From: Carol Reynolds
Sent: 18 June 2018 10:24
To: Planning.Responses
Cc: Anita Gardner
Subject: FW: Please find attached amendment on planning application Ref: A/219/17/PL

APPLICATION NO: A/219/17/PL

Site Address: Land East of Windy Ridge Mayflower Way, Angmering BN16

Description of Works: 12No. Social dwellings for Angmering Community Land Trust, including two communal bike stores, a pedestrian mews and orchard. Departure from the Development Plan.

B Terrace B - West: Front Elevation

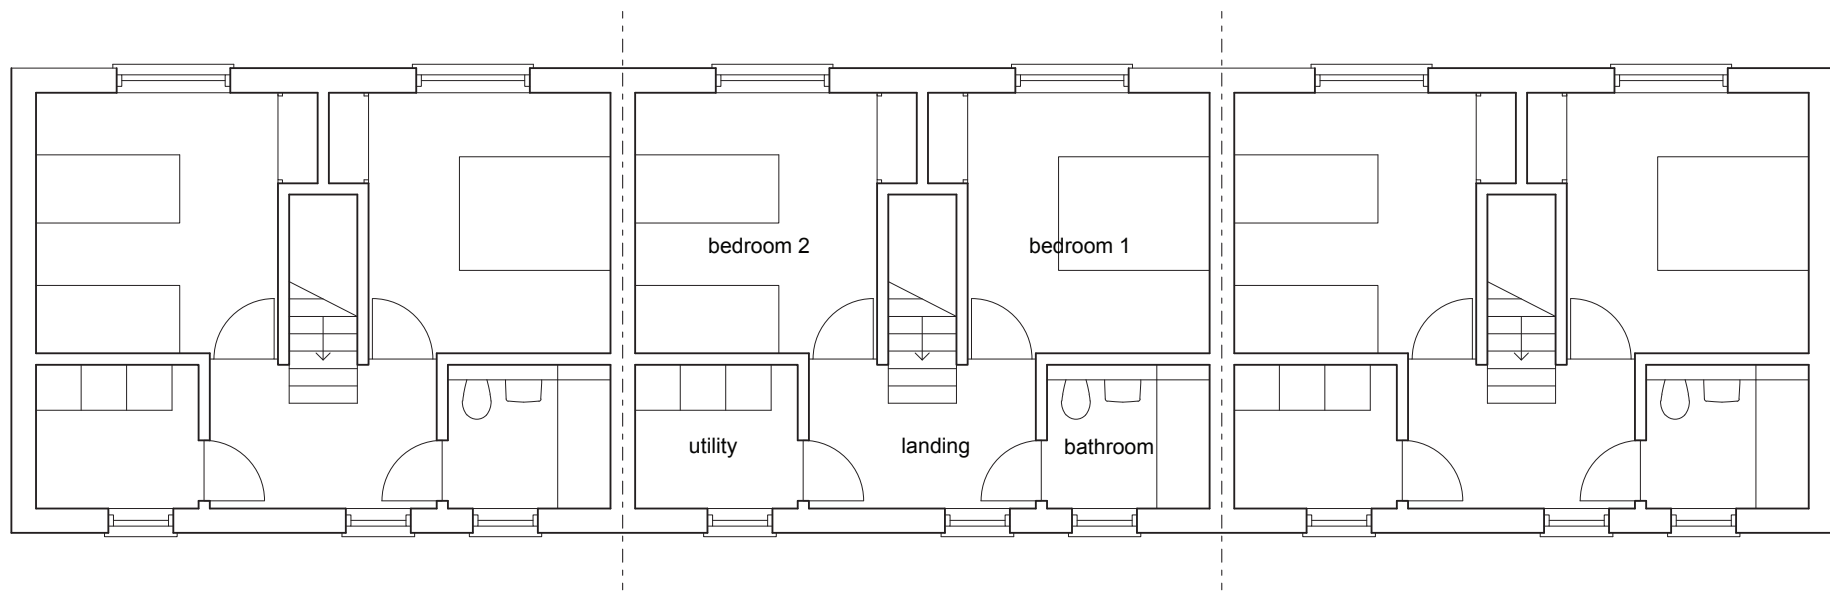
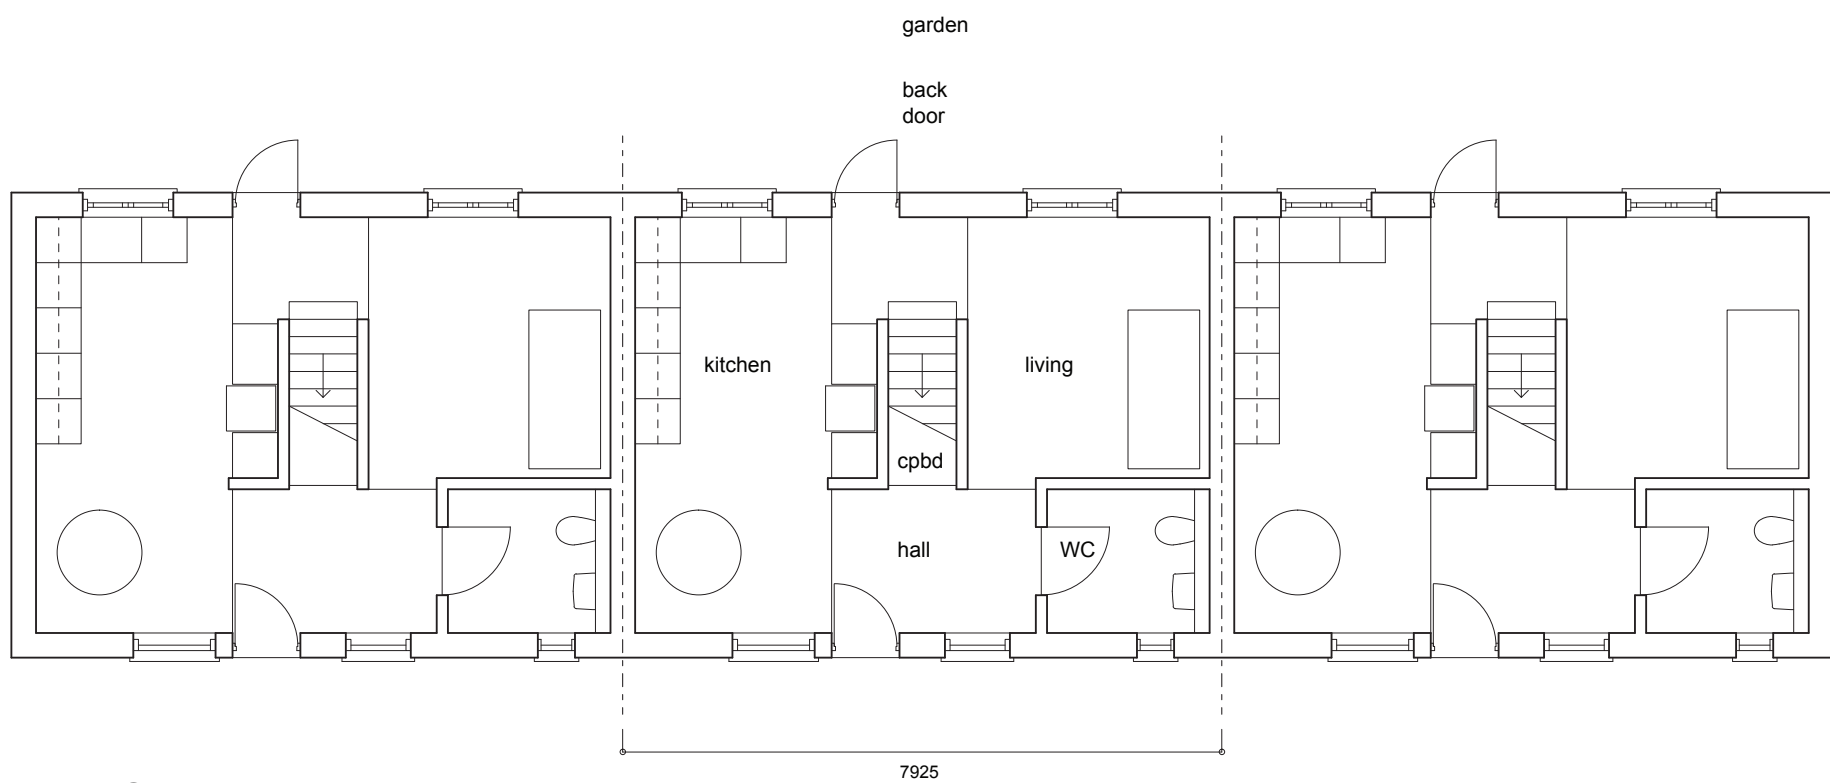
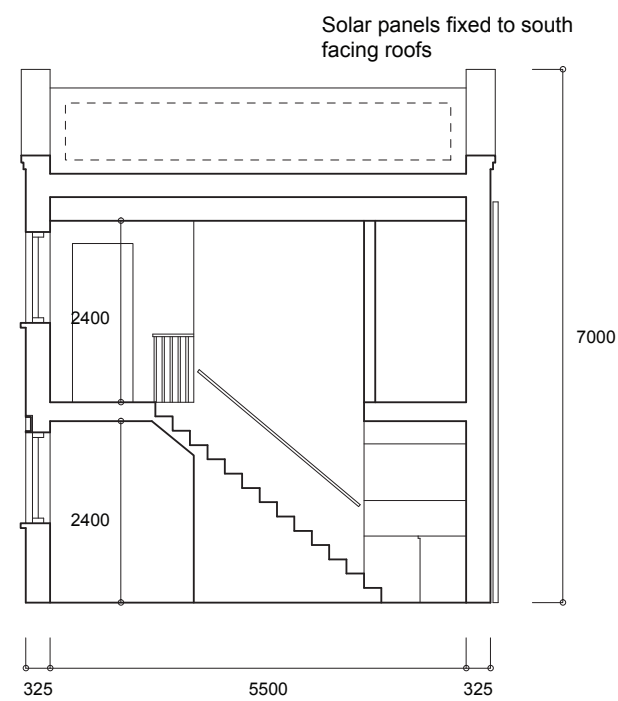
Fire Safety, Terraces A-C. The only means of escape in the event of fire from first floor bedrooms is through an open plan kitchen/diner and so these bedrooms are inner rooms. The hazard can be mitigated by creating a ground floor lobby from the stairs to the front door which would be necessary in every case.

Terrace C - West: Rear Elevation

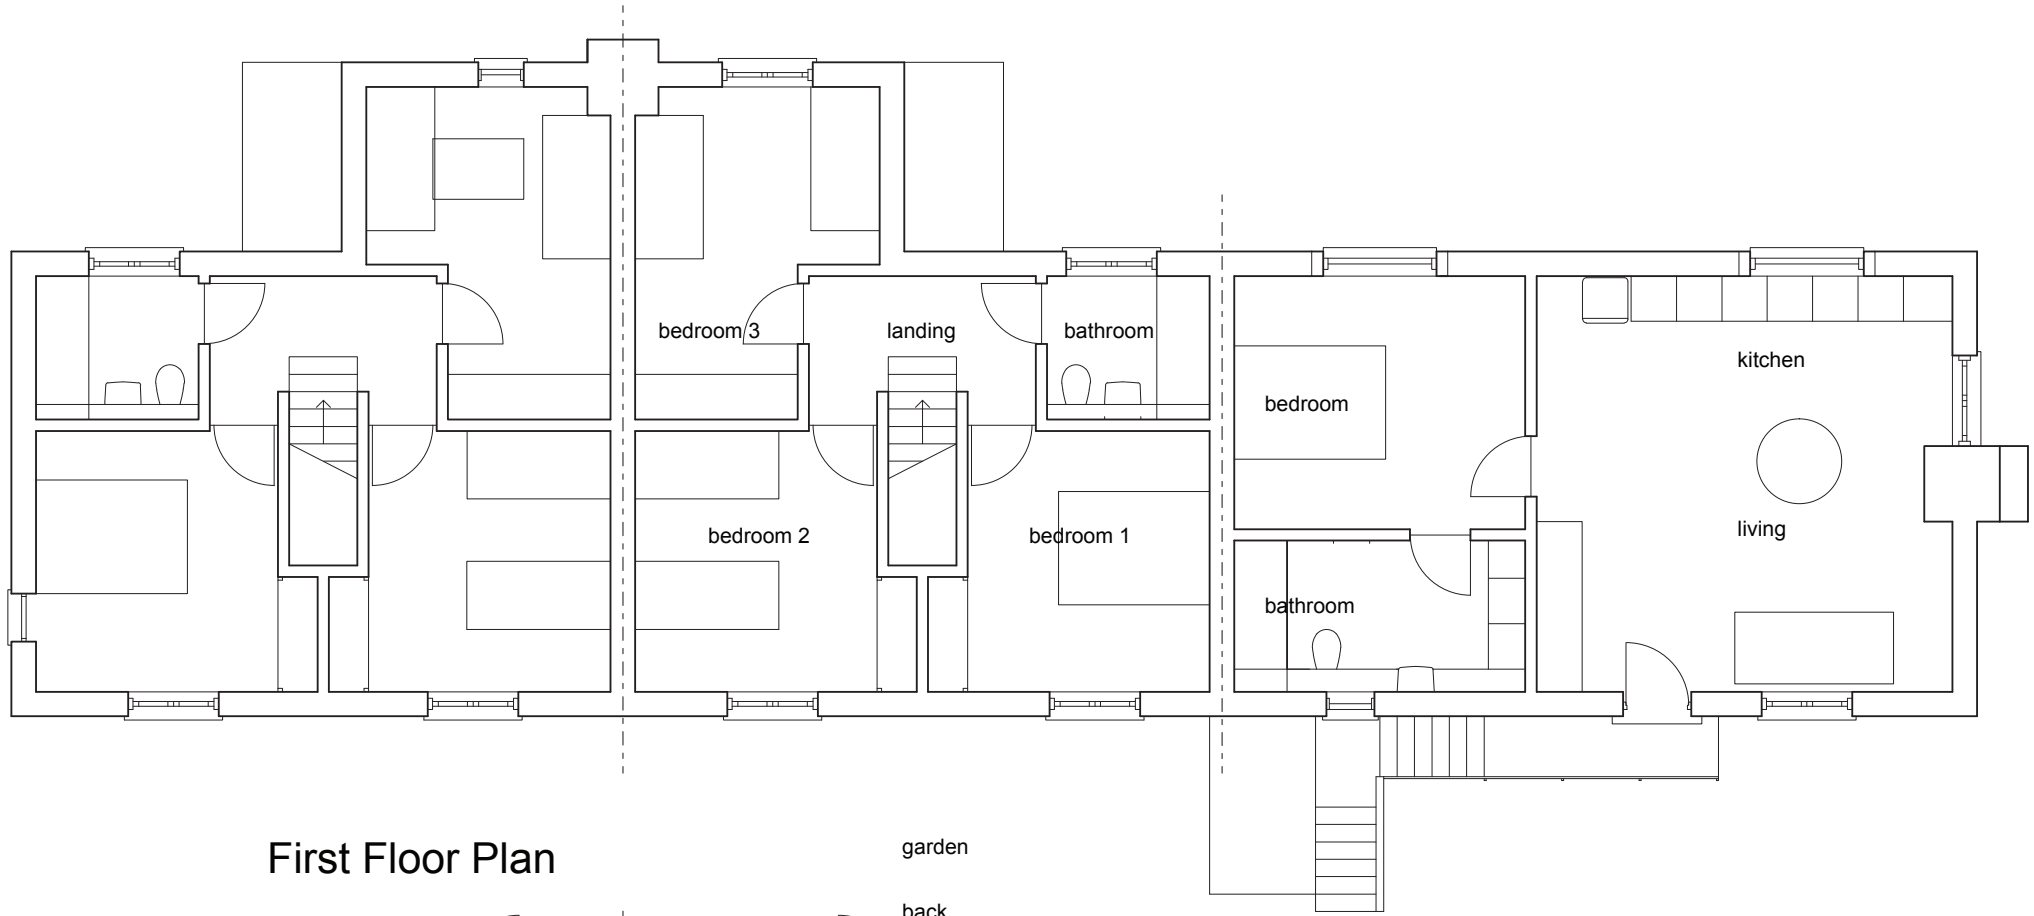
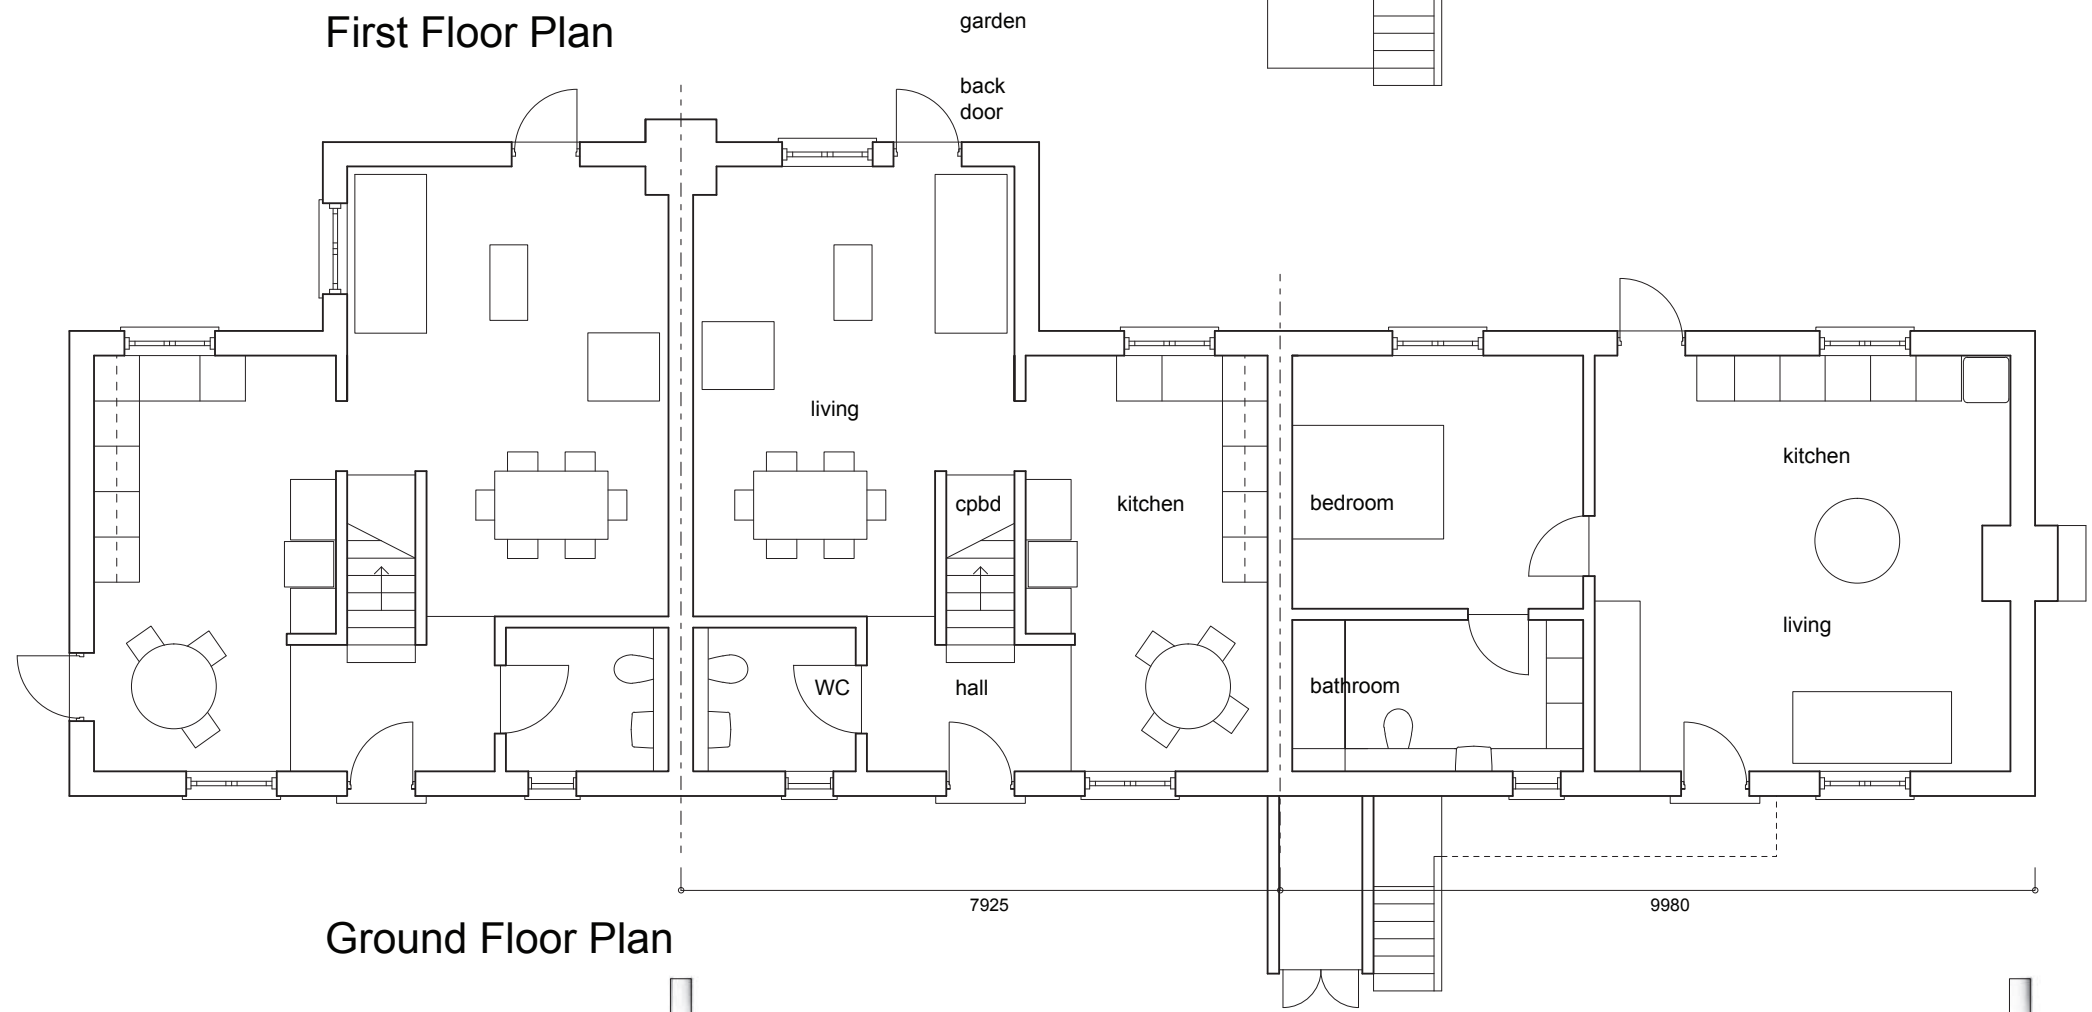
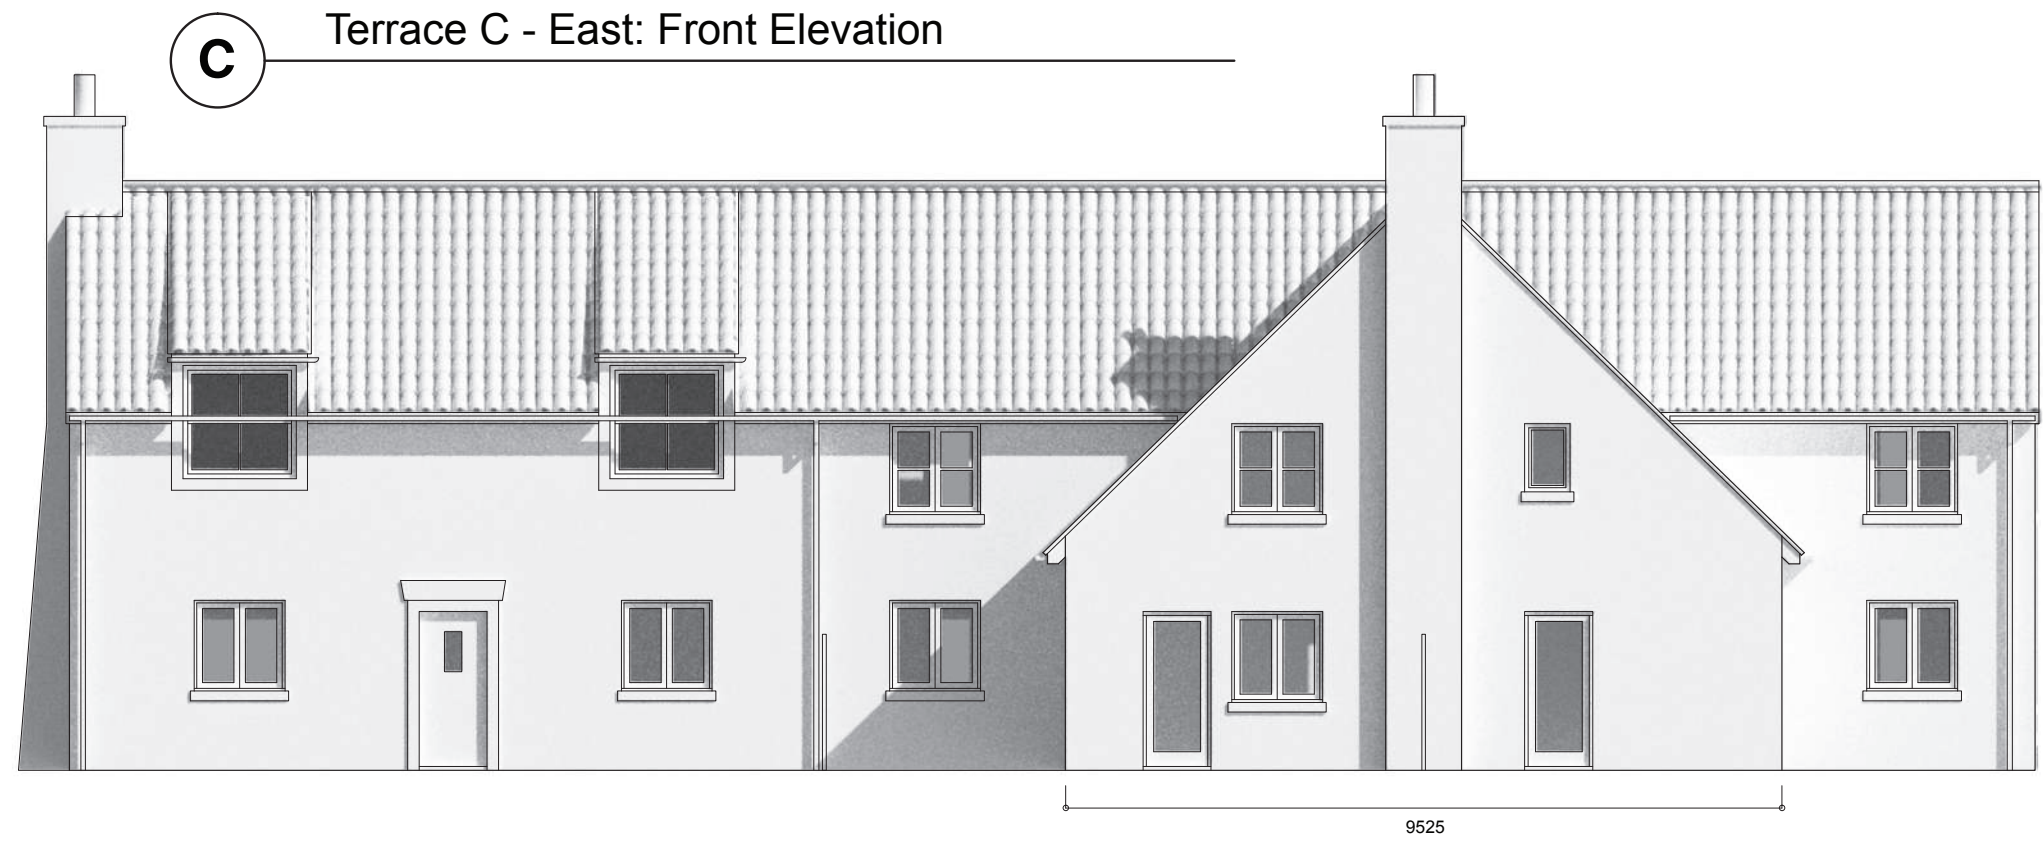
The only means of escape in the case of the flats in Terrace C is through the open plan kitchen and so they are inner rooms. The risk can be mitigated in the ground floor flat by ensuring that the bedroom window complies with fire escape window requirements. There is no easily apparent way of mitigating the risk in the first floor flat as fire escape windows at first floor or above are not acceptable to Environmental Health since this replaces one hazard with another.
